**Sent:** 29 June 2009 22:11  
**To:** Planning  
**Subject:** Welwyn Hatfield Council Online Planning - Comment

**Application Number:** S6/2009/0891/MA

DRAWING TITLE
B29 - ELEVATIONS

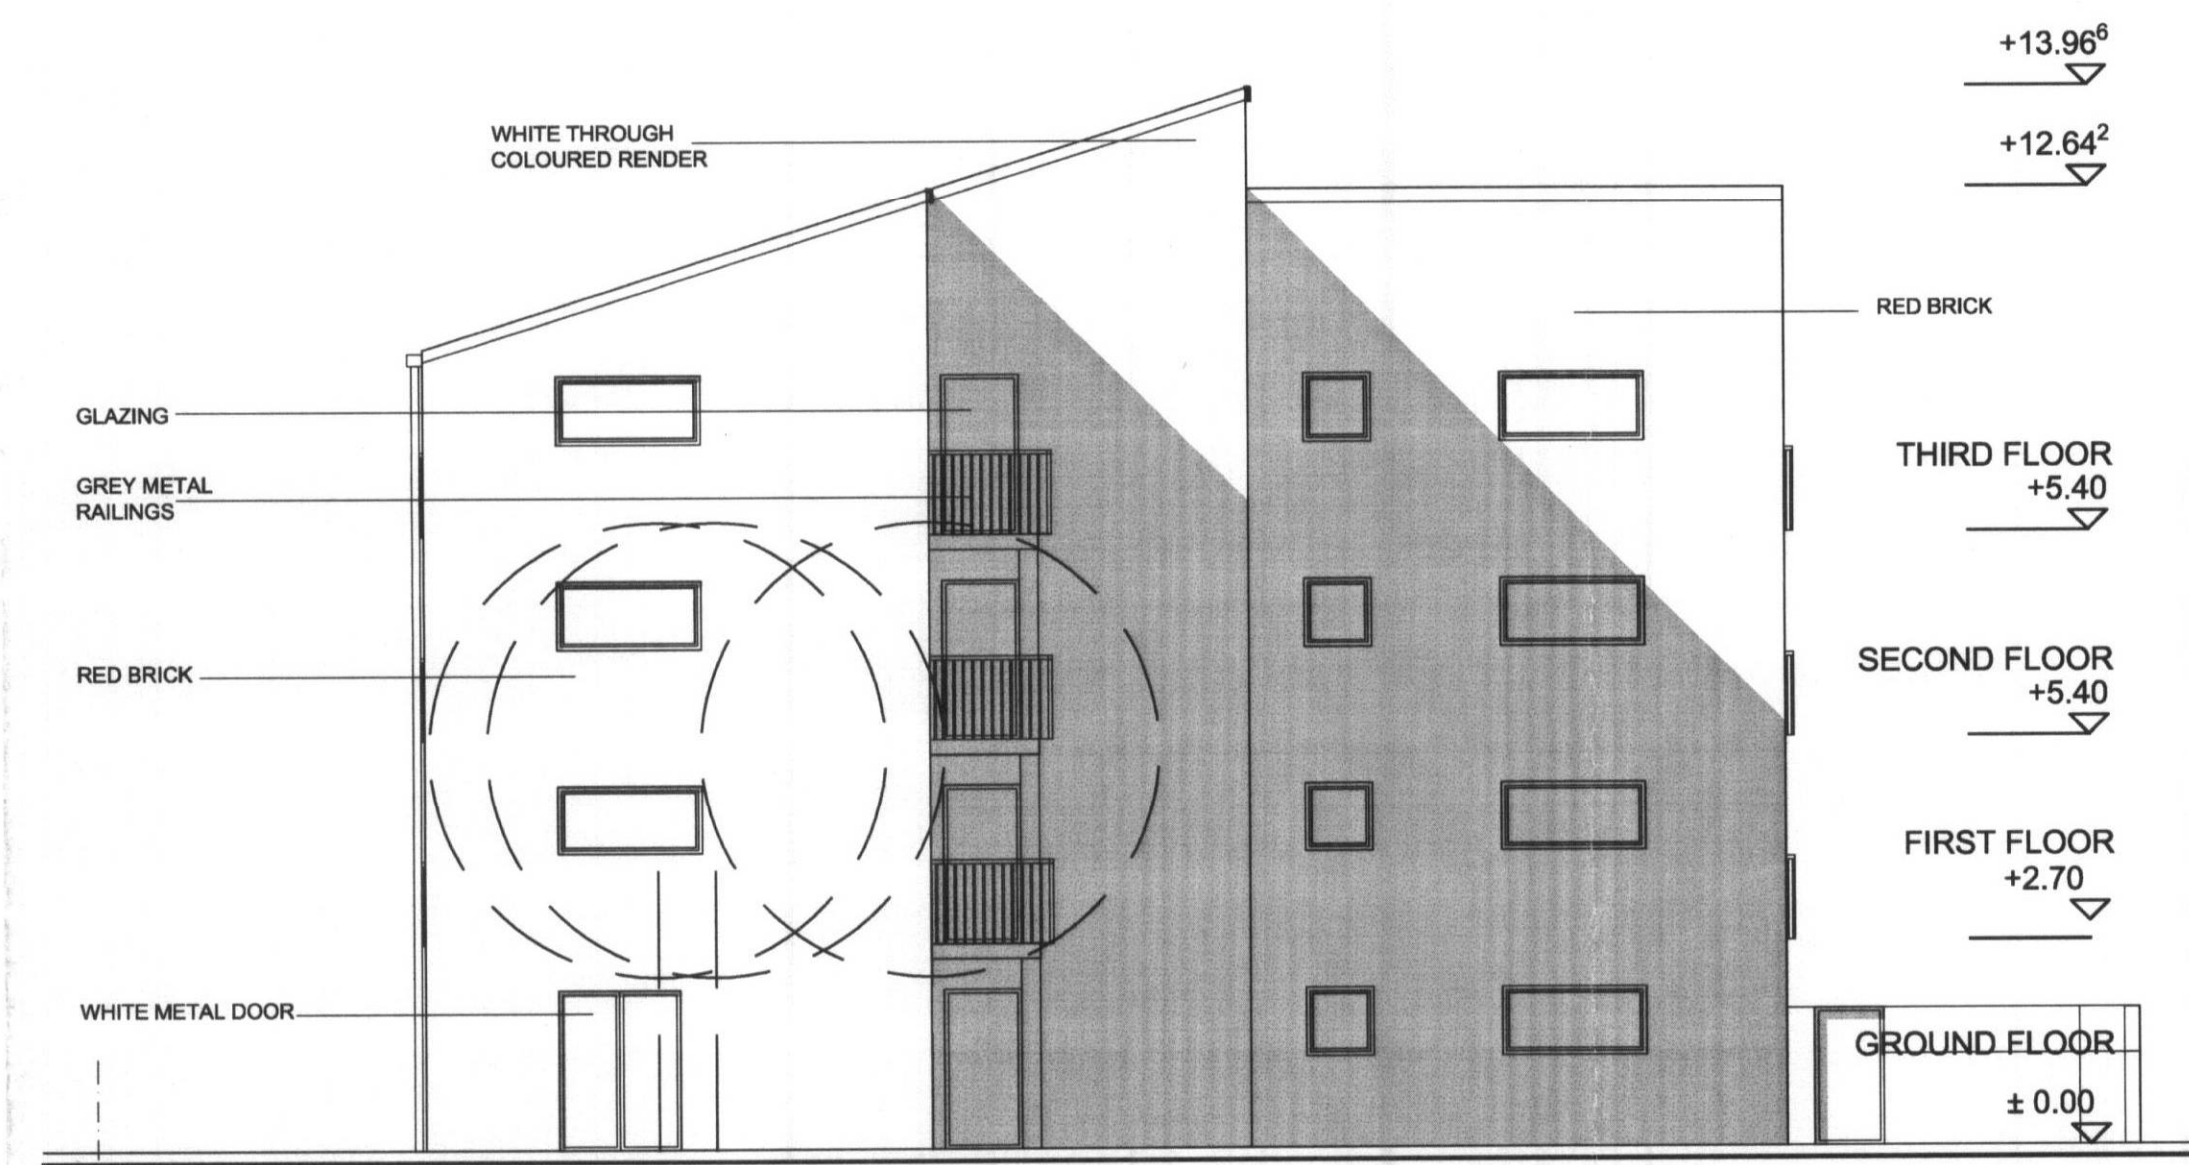
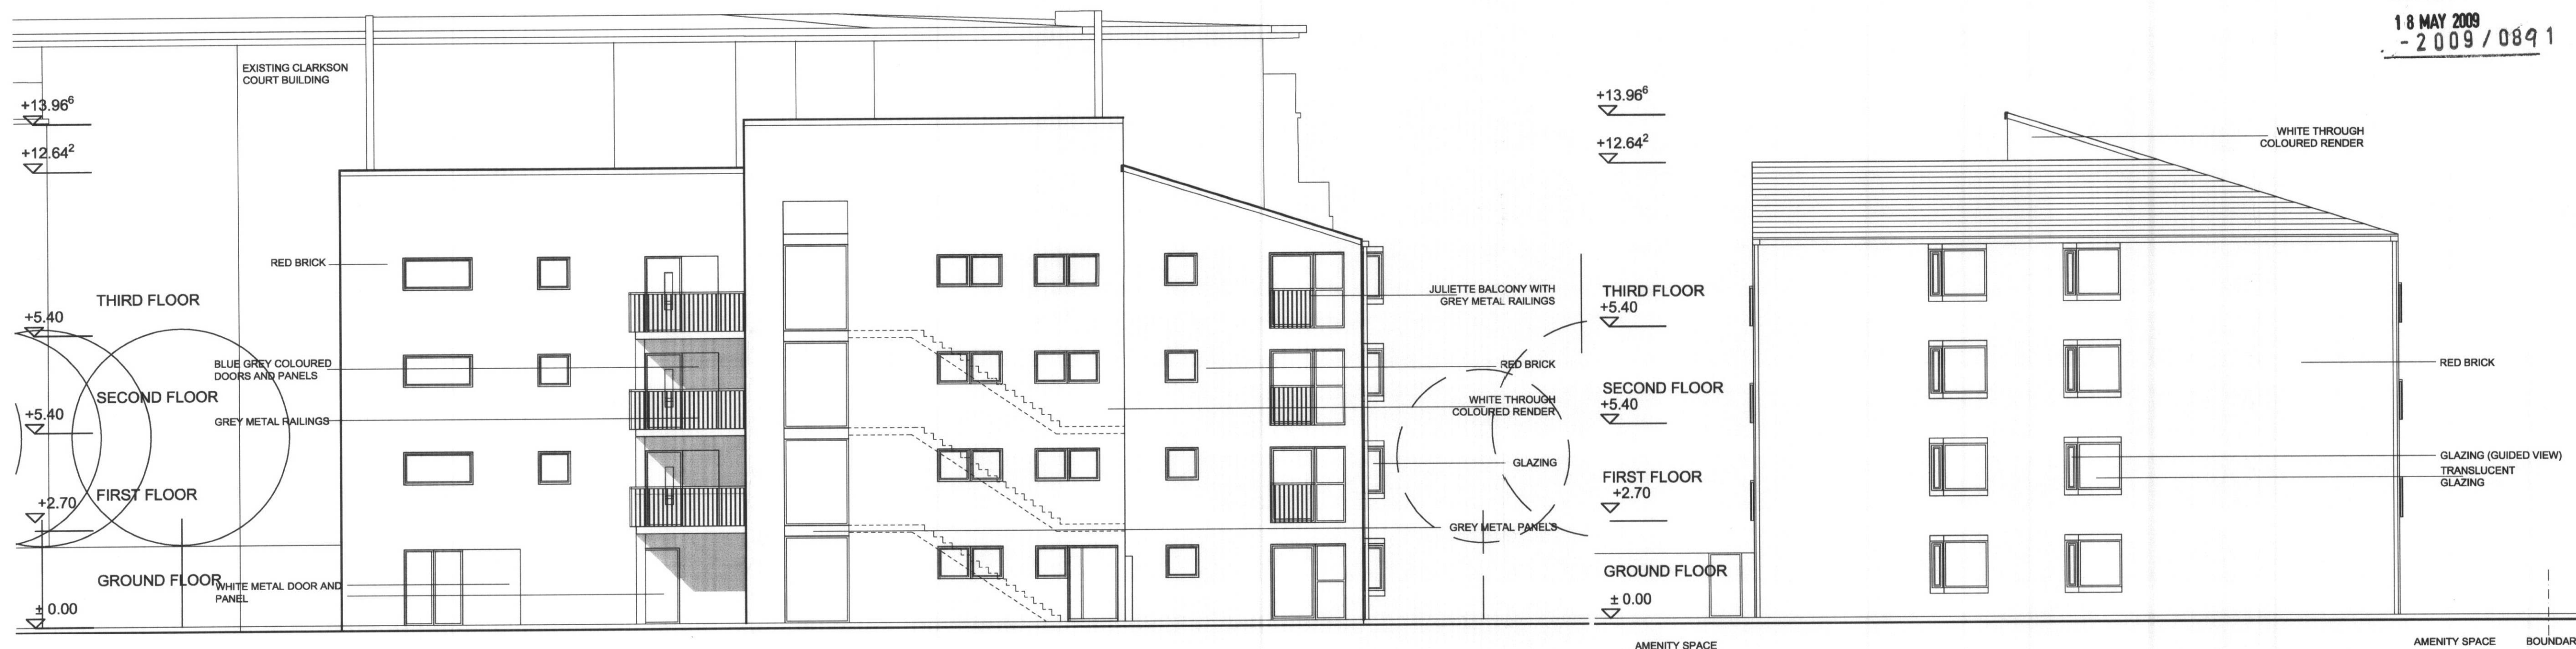
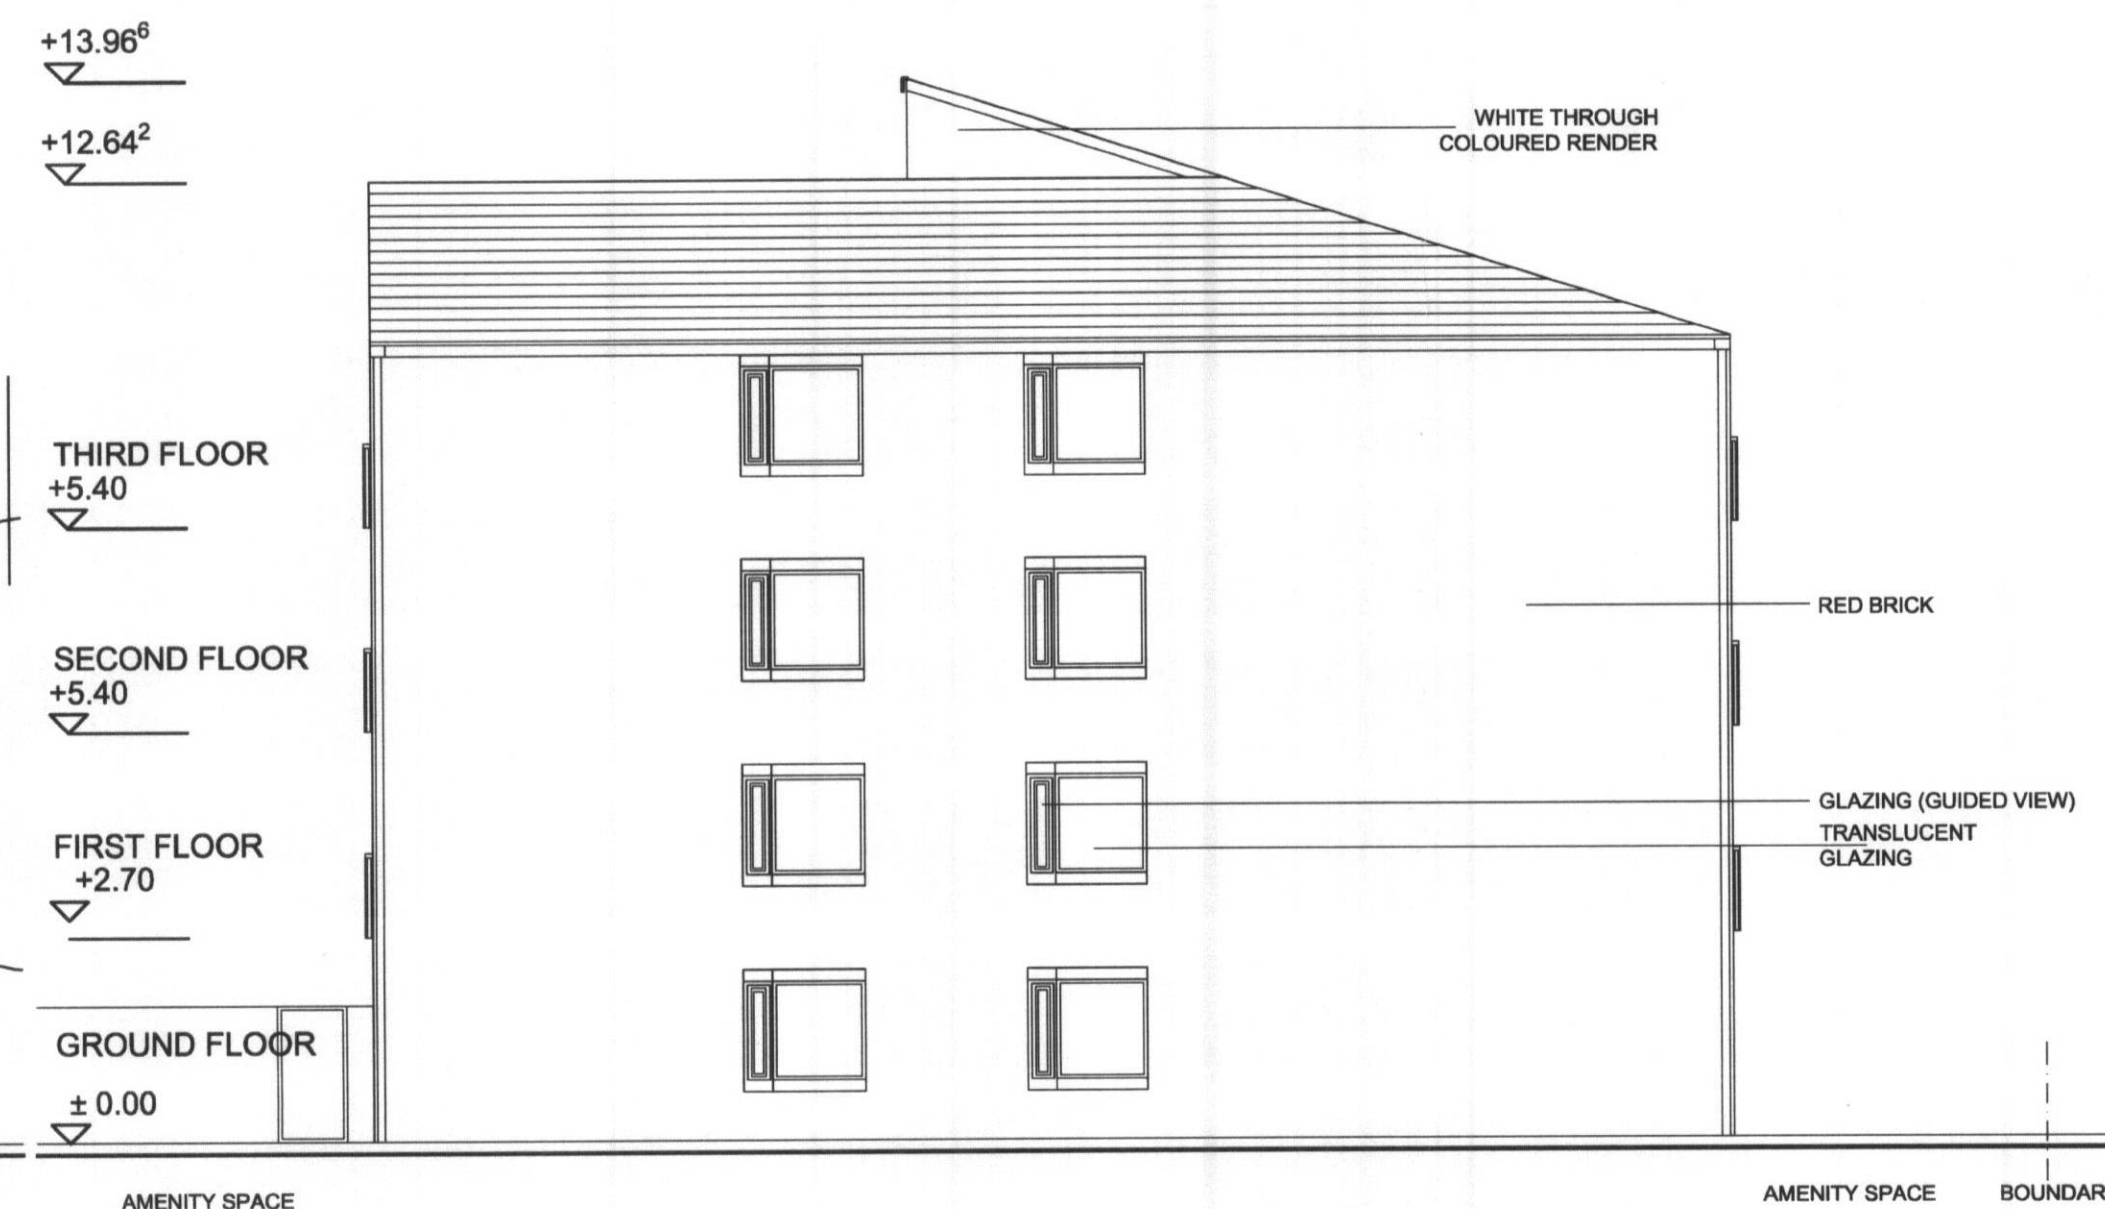
**Building B29** will not allow for much privacy for those living in Clarkson Court and vice versa. The plans only refer to one bin store for this building which is 15 apartments, this does not seem sufficient.
